KIRKLEES METROPOLITAN COUNCIL INVESTMENT & REGENERATION SERVICE

DELEGATED DECISION TO DETERMINE APPLICATIONS FOR CONSENT, AGREEMENT OR APPROVAL REQUIRED BY CONDITION

Reference No:	2026/44/92301/E
Site Address:	Kami Healthcare Ltd, 8, Market Place, Birstall, Batley, WF17 9EL
Description:	Discharge of details reserved by conditions 2 (heritage colour of shopfront), 3 (sections of proposed timber mullions and shopfront) and 4 (stall riser details) on previous permission 2025/93140 for installation of replacement shop front and internal shutter (within a Conservation Area)
Recommending Officer:	Nicole Helliwell

DECISION – Discharge of Conditions - Approved

Rev	Description	Date
Client		
Barham Mohamadi		
Address		
8 Market Place Birstall, Batley WF17 9EL		
Title		
Cross Section B-B		
PP-Front-Market place		
1:20@A3	Date	06/08/26

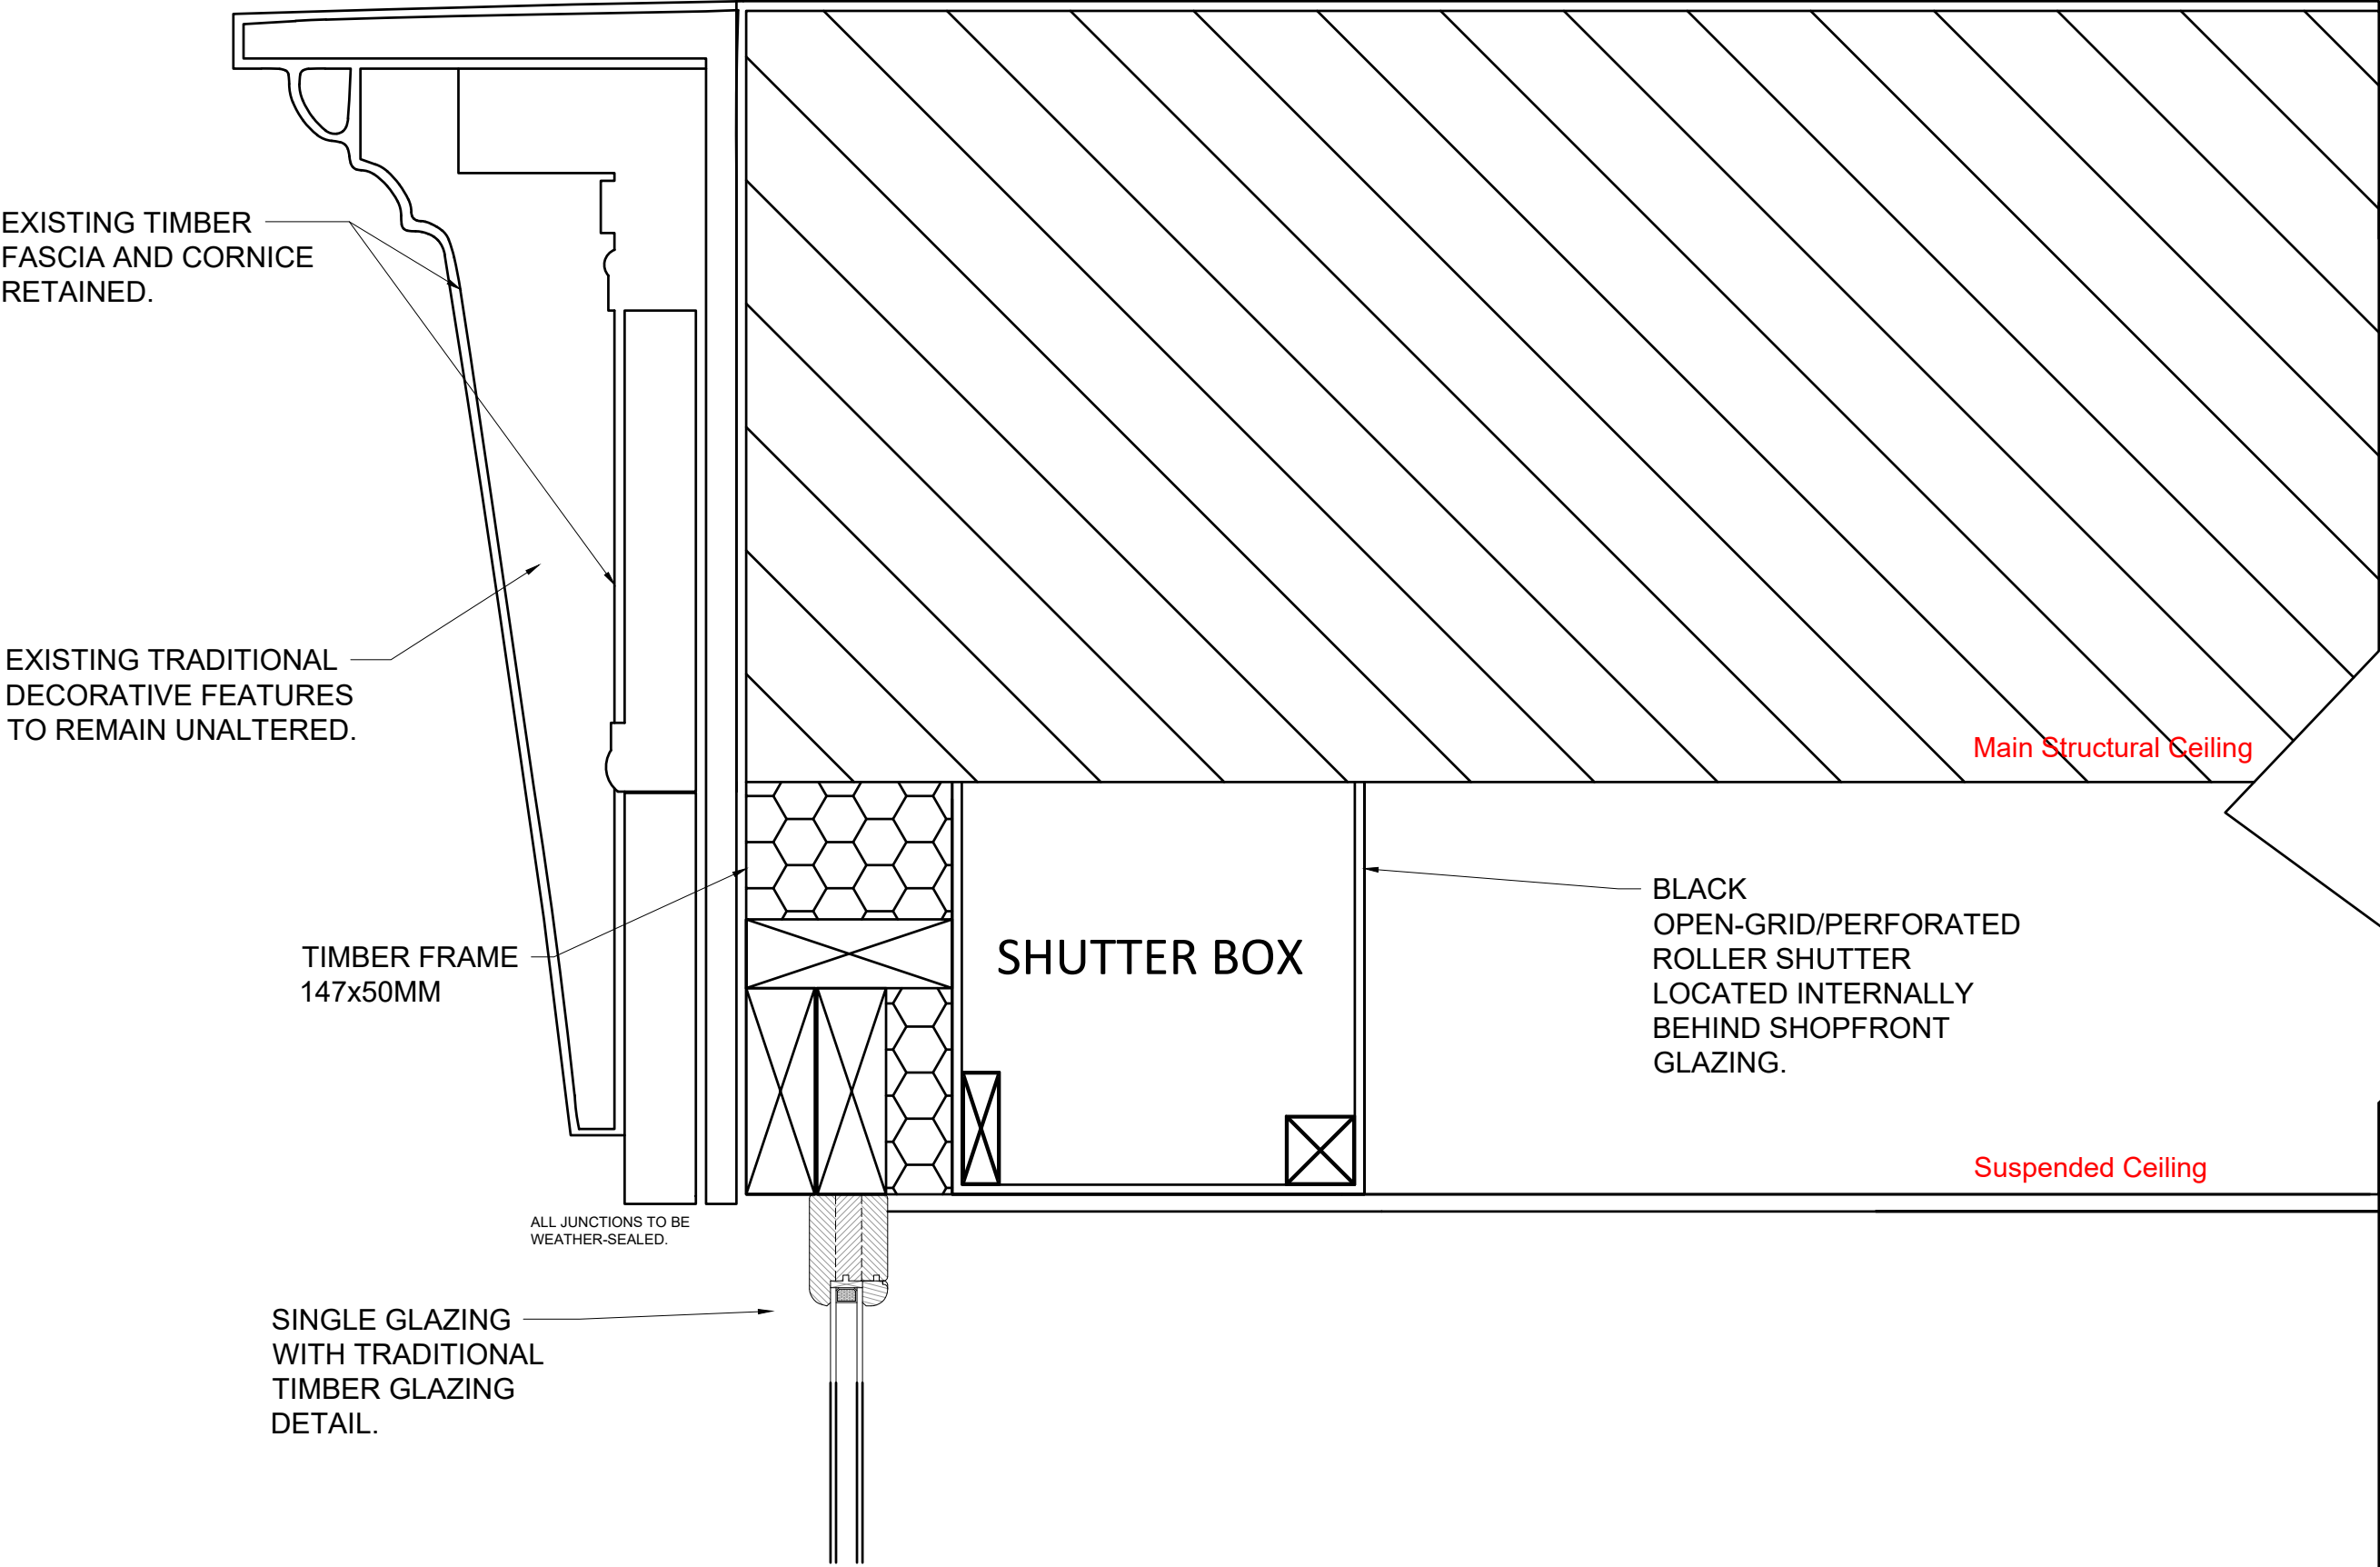
The applicant has submitted plans titled 'Detail A & Cross Section A-A' (dated 6th August 2026), 'Cross Section B-B' (dated 6th August 2026) and 'Cross Section C-C & Cross Section D-D' (dated 6th August 2026) in support of condition 3. KC Conservation and Design have confirmed that the proposed timber mullions either side of the central entrance doorway will have circular turned sections on a square base of a similar design to the previous shop front

which is acceptable. Therefore, the submitted details are considered acceptable for the purposes of Condition 3 and therefore the condition can be discharged.

Rev	Description	Date
Client		
Barham Mohamadi		
Address		
8 Market Place Birstall, Batley WF17 9EL		
Title		
Front Elevation		
PP-Front-Market place		
1:20@A3	Date	06/08/26

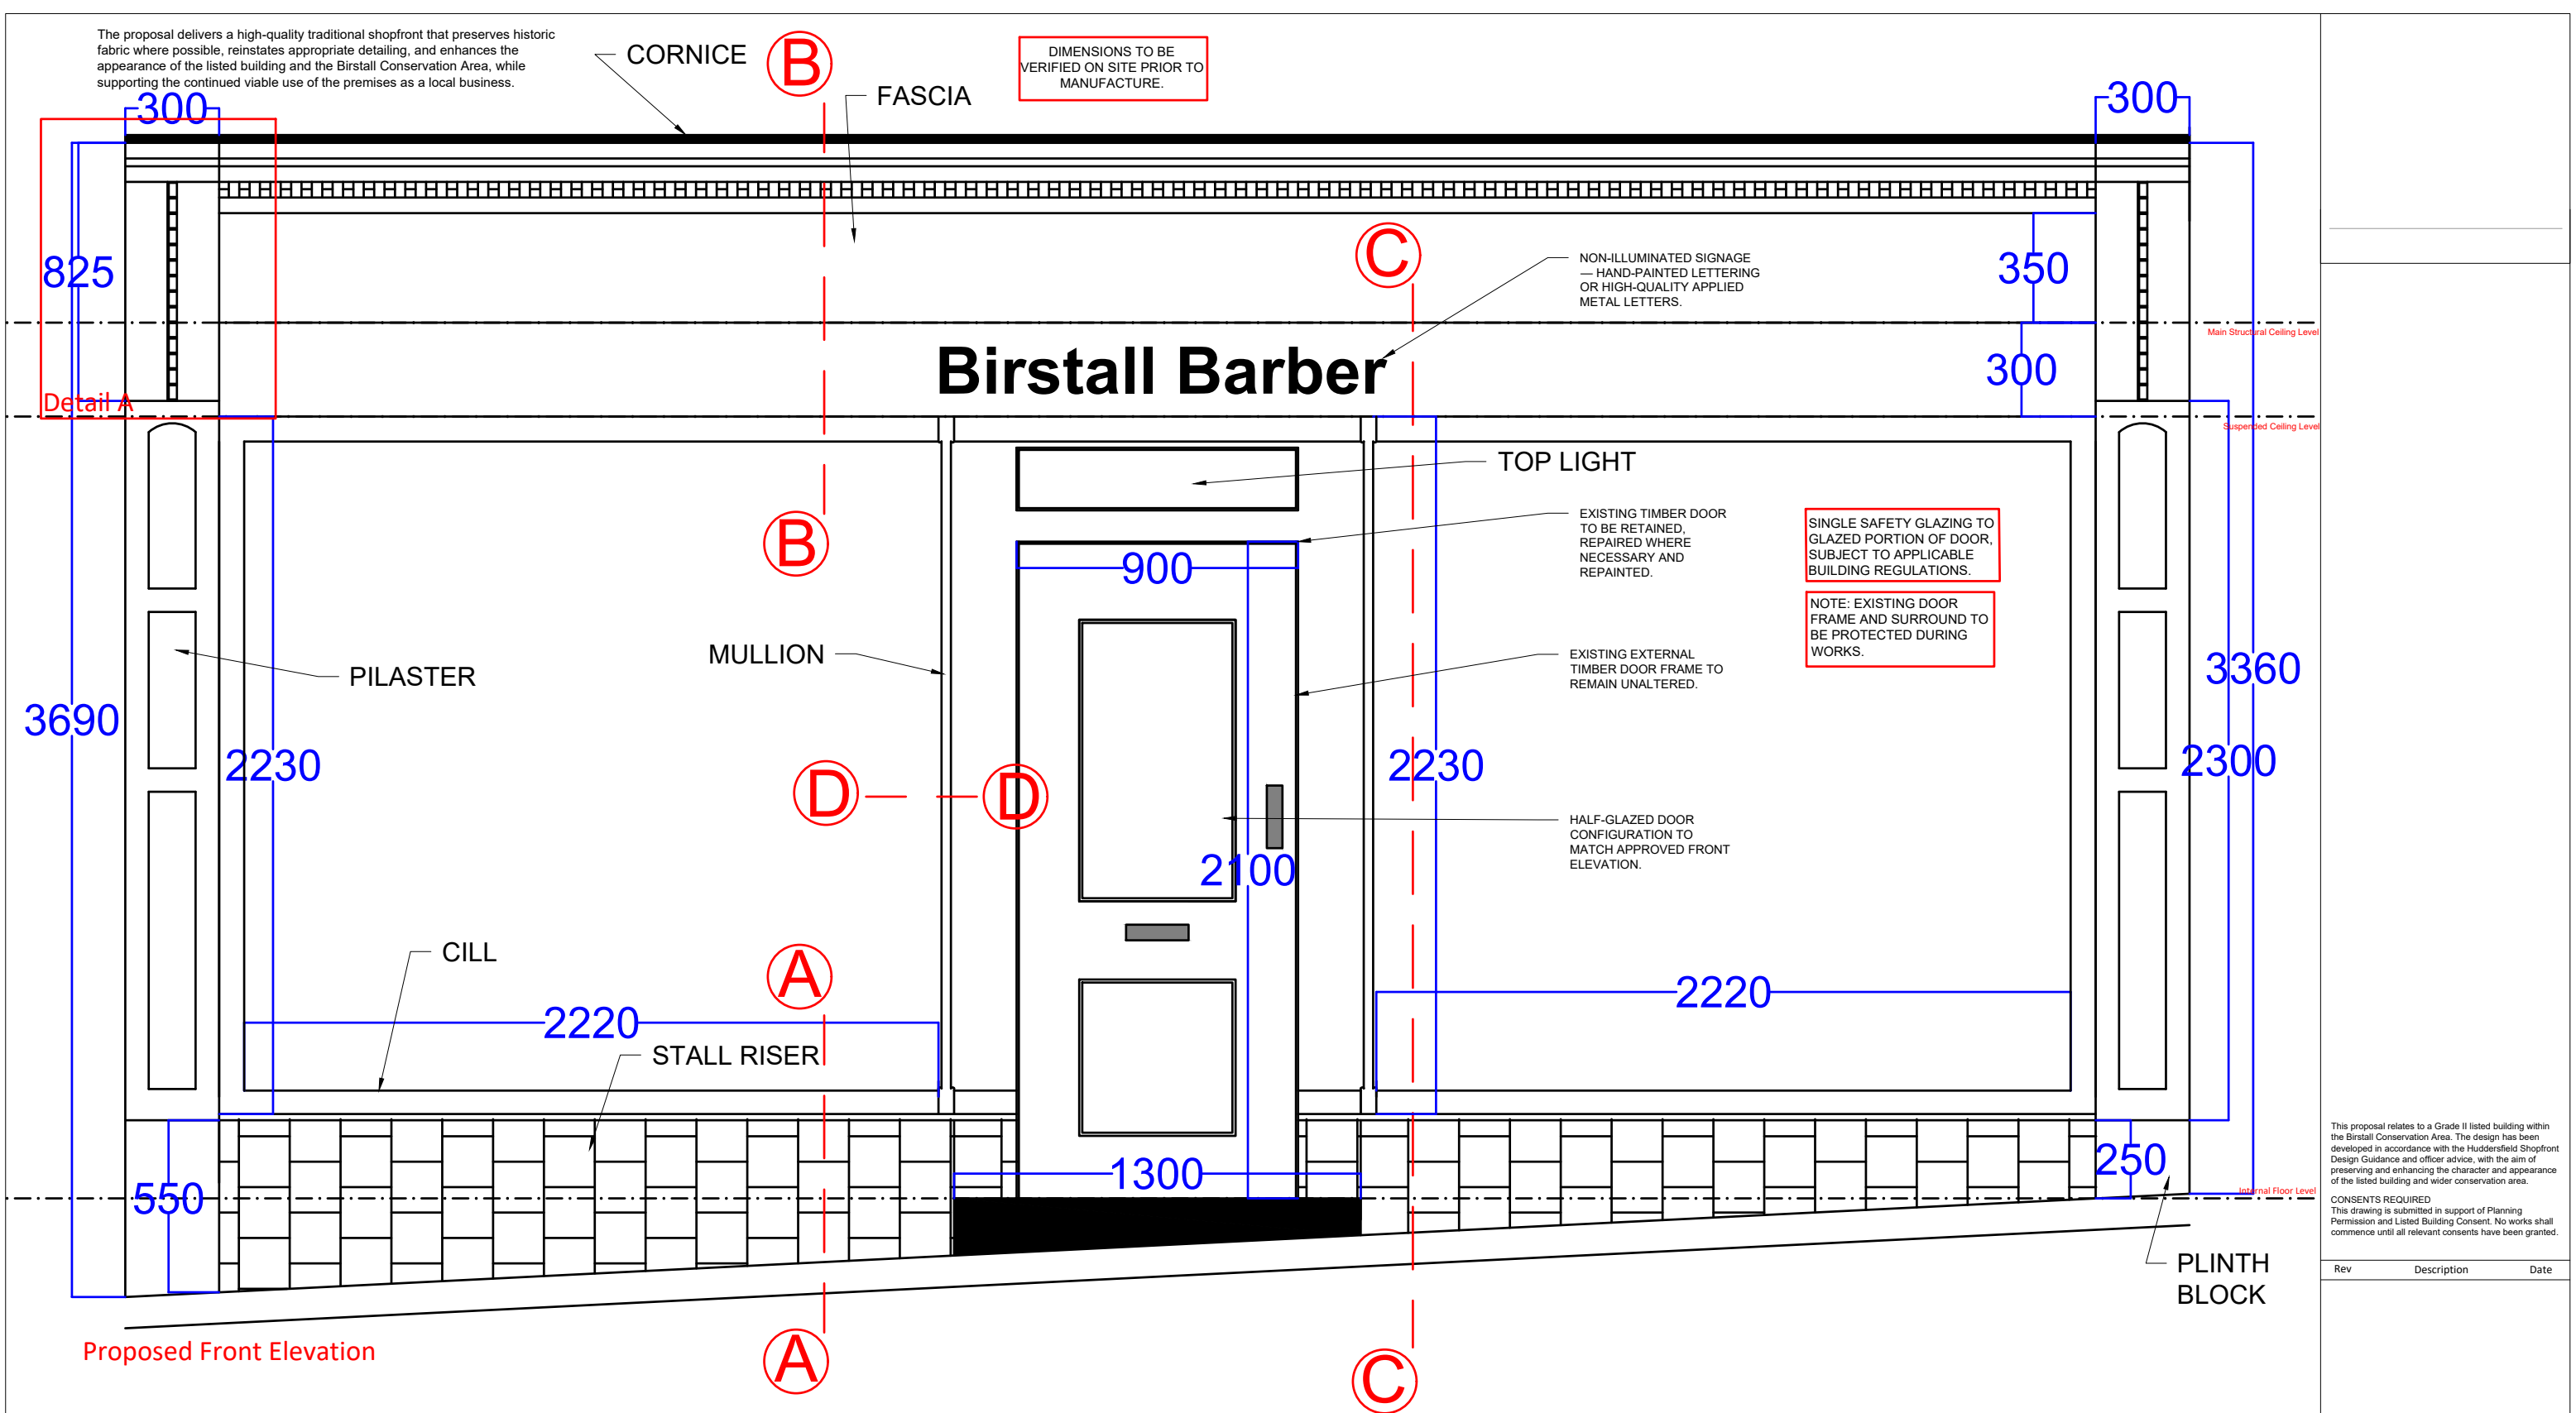
The applicant has submitted a plan titled 'Front Elevation' (dated 6th August 2026) in support of condition 4. The plan states that the proposed tiles will be of the same size, profile and type as the existing tiles. As such, KC Conservation and Design have no objection to the discharge of condition 4.
